I am Rosemary Lewis, a resident of the village of Church Hanborough and adjacent to the western boundary of the Central site which comprises 70% of the entire proposal. Two particular concerns for local residents are TRAFFIC and NOISE .

I believe the issue of heavy traffic and congestion in this area has not been adequately assessed by the Applicant and would draw the Inspector's attention to the following facts drawn from local knowledge, daily use and actual observations of local roads (ref *map*)

Peak Daily Construction Vehicle Generation (Total Vehicles, HGVs, Tractors and Trailers)

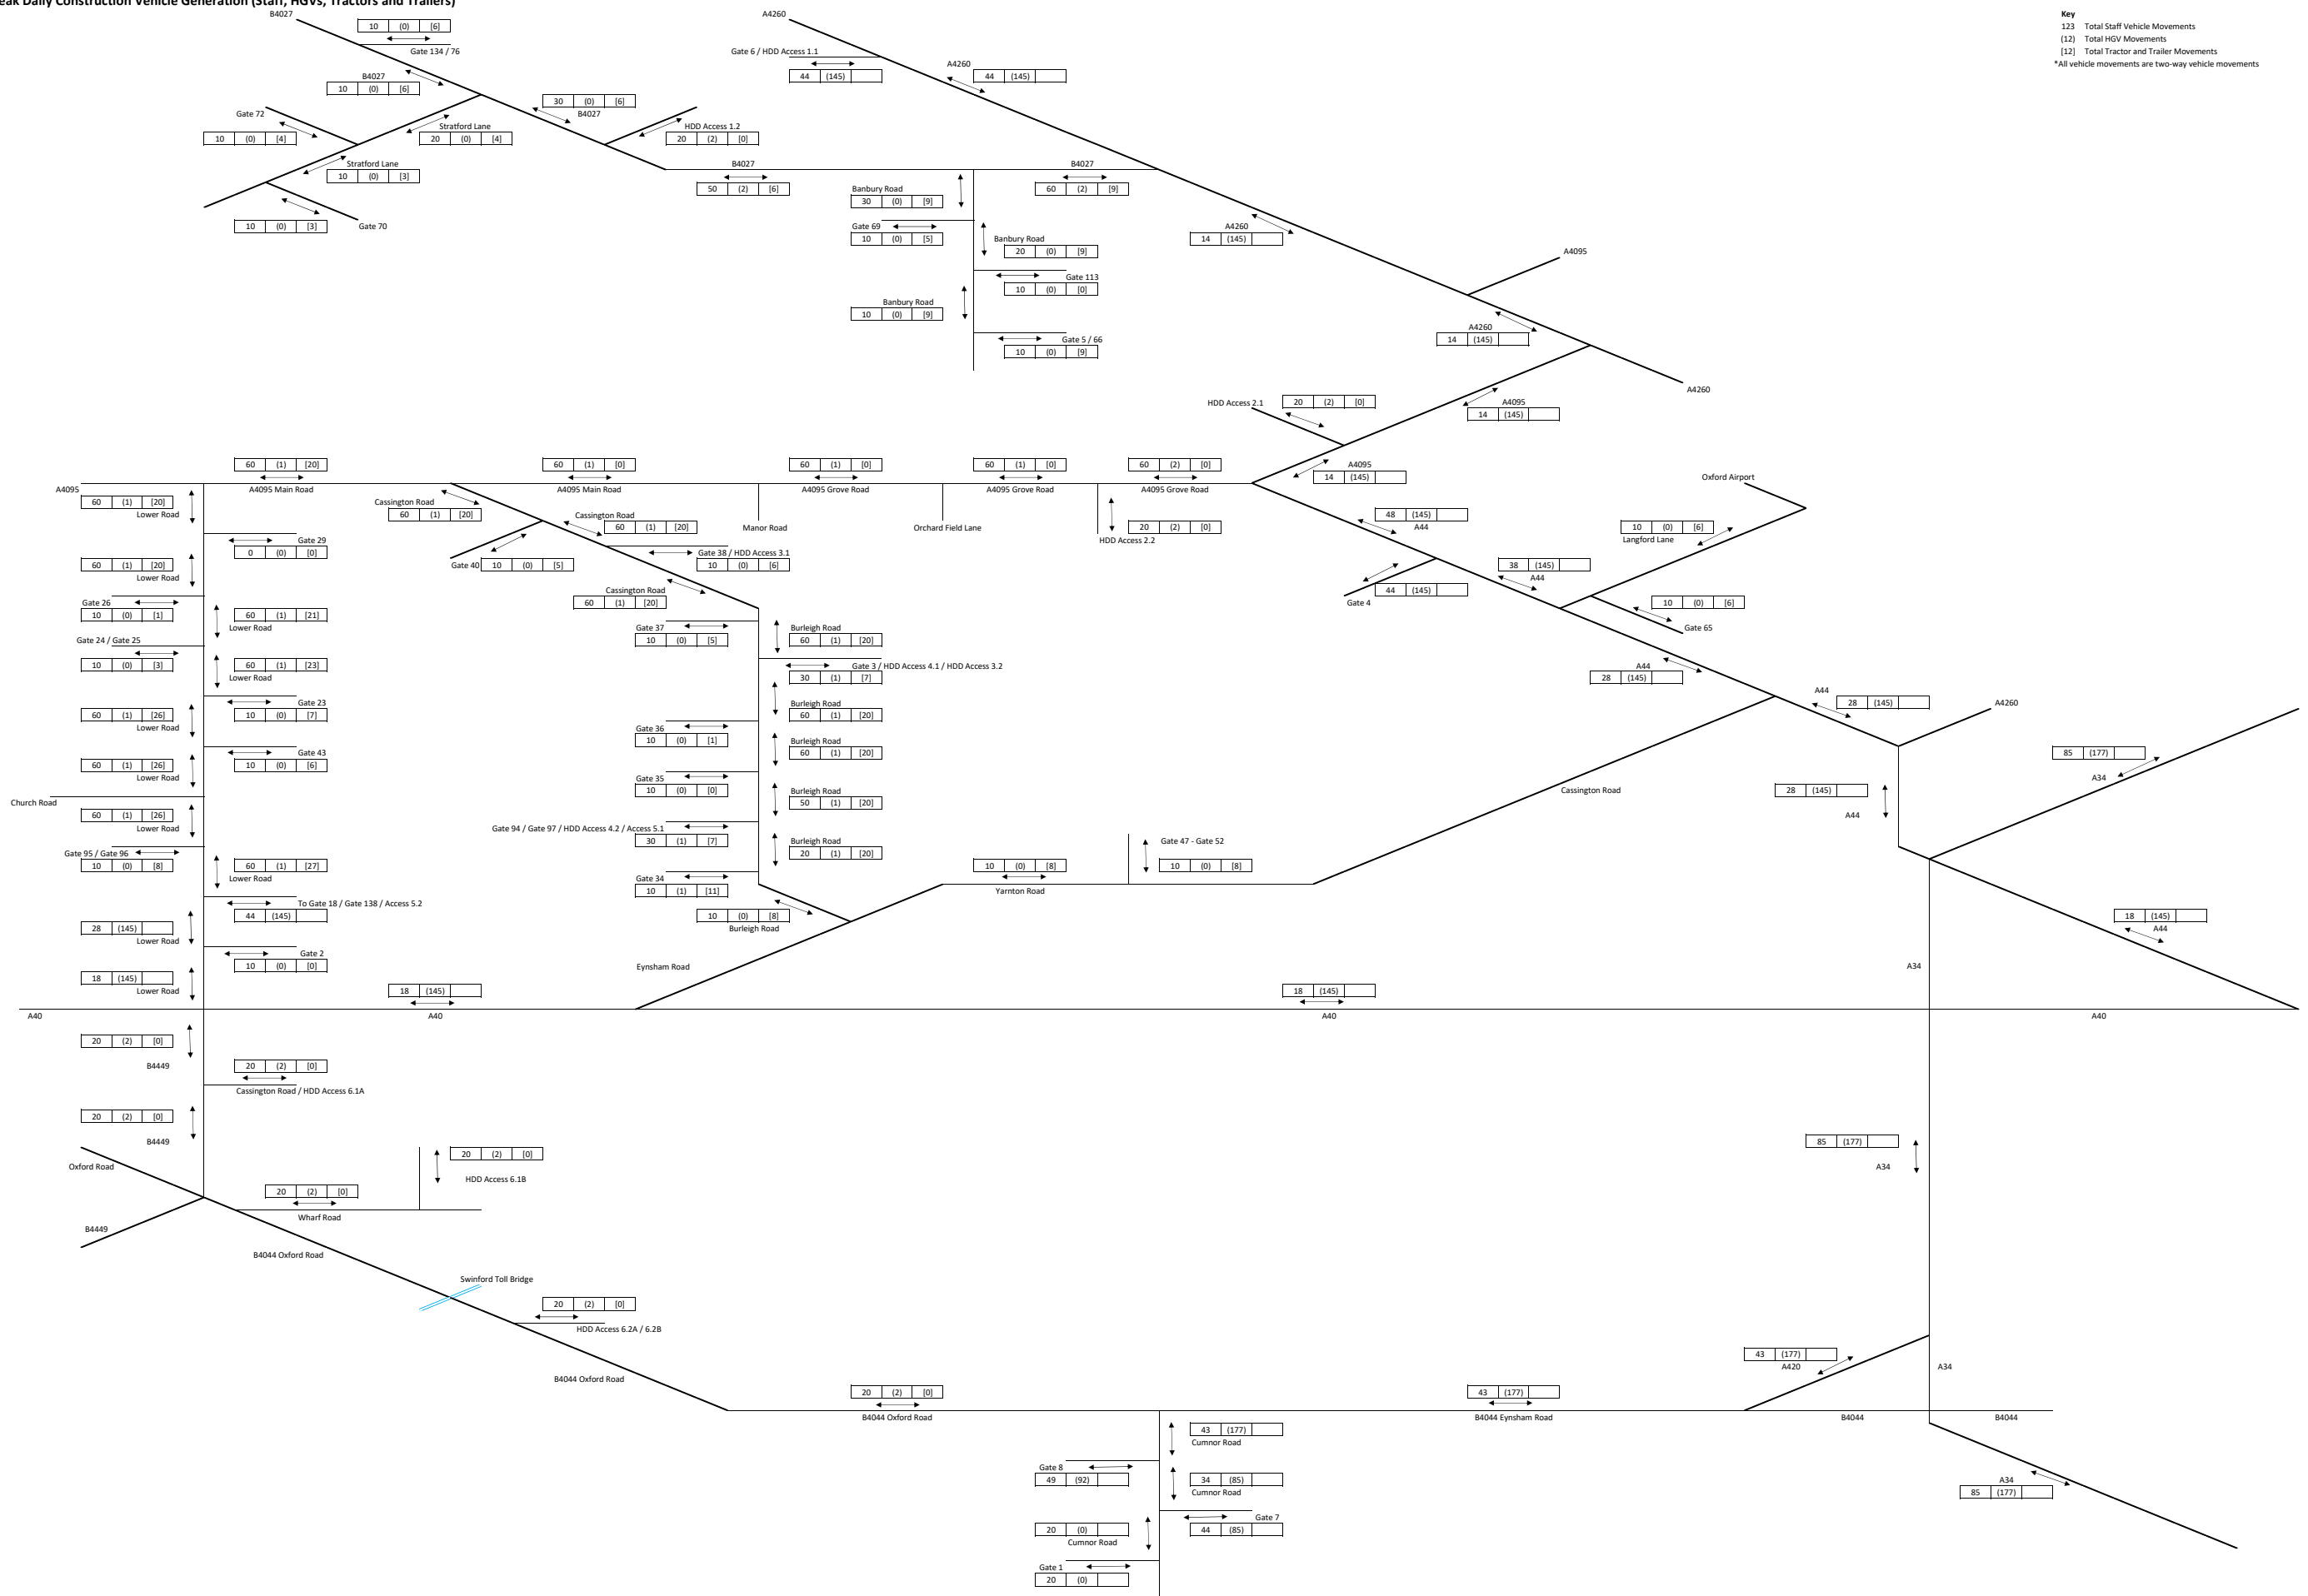
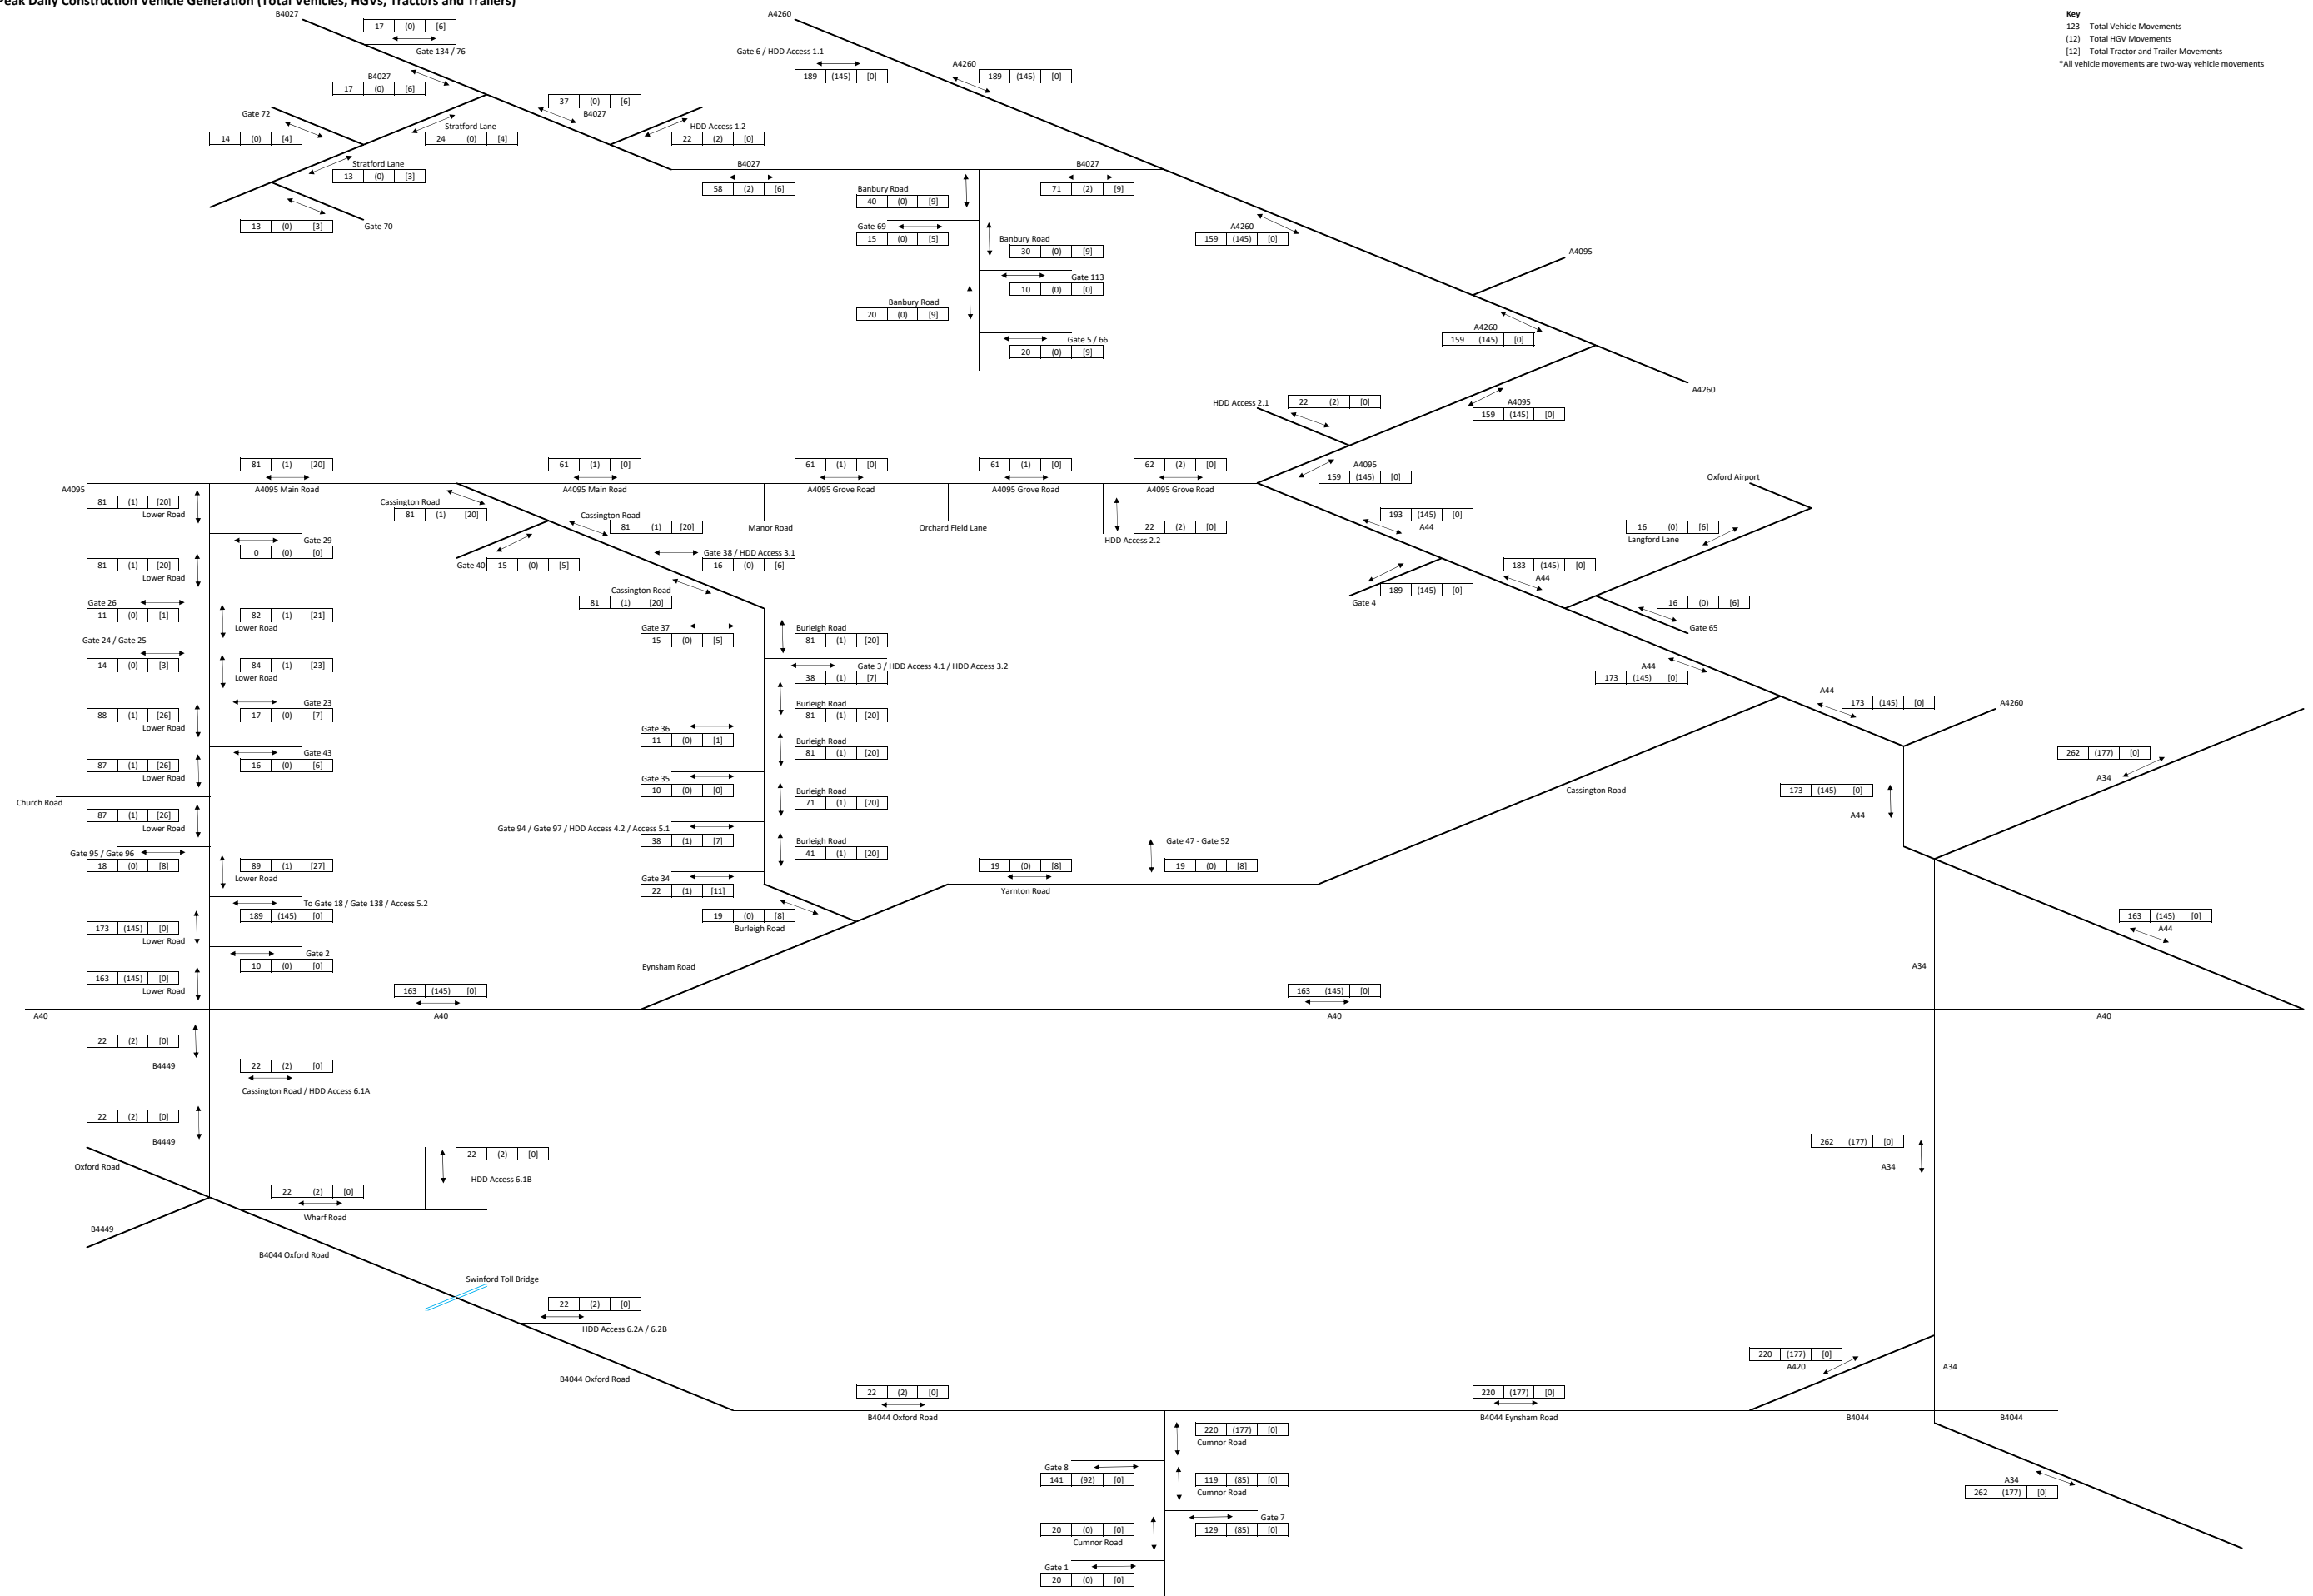
1. At the junction between A4095 and Lower Rd (*black circle*) traffic frequently queues for 500m as far as the low narrow railway bridge (*black hoop*) which is too narrow for a lorry to pass a car and unsuitable for large HGVs or AILs. The queue restricts access into the prestigious Wolfram Institute and other businesses near the junction. More traffic turning onto Lower Rd to access the fields of solar panels will further delay the traffic trying to turn out.

2. To avoid the queues, cars would cut through Church Hanborough, an unsuitable alternative as the road is narrow and winds through the village where there is no pavement, no lighting and many properties adjacent to the road.

3. The Applicant is proposing 7 additional access points to the site from Lower Road. These will be added to the many tracks and property driveways, the turn to City Farm hamlet and the busy junction with Church Road. (*17 turn offs in purple*).

4. Lower Road has no speed limit and contains long straight stretches but also has bends and contour changes restricting sight lines in places.
5. The Applicant's new public access path to run alongside Lower Rd and to cross it twice is a dangerous proposal.

6. The A4095 itself is unsuitable for construction traffic because it passes directly through Long Hanborough and Bladon where it is narrow and winding causing a serious hazard to pedestrians.

A safer access route to the site in this area would be from the A40 roundabout approaching Lower Rd from the south as this passes just 4 of the 17 turn offs to reach the proposed substation and fields beyond.
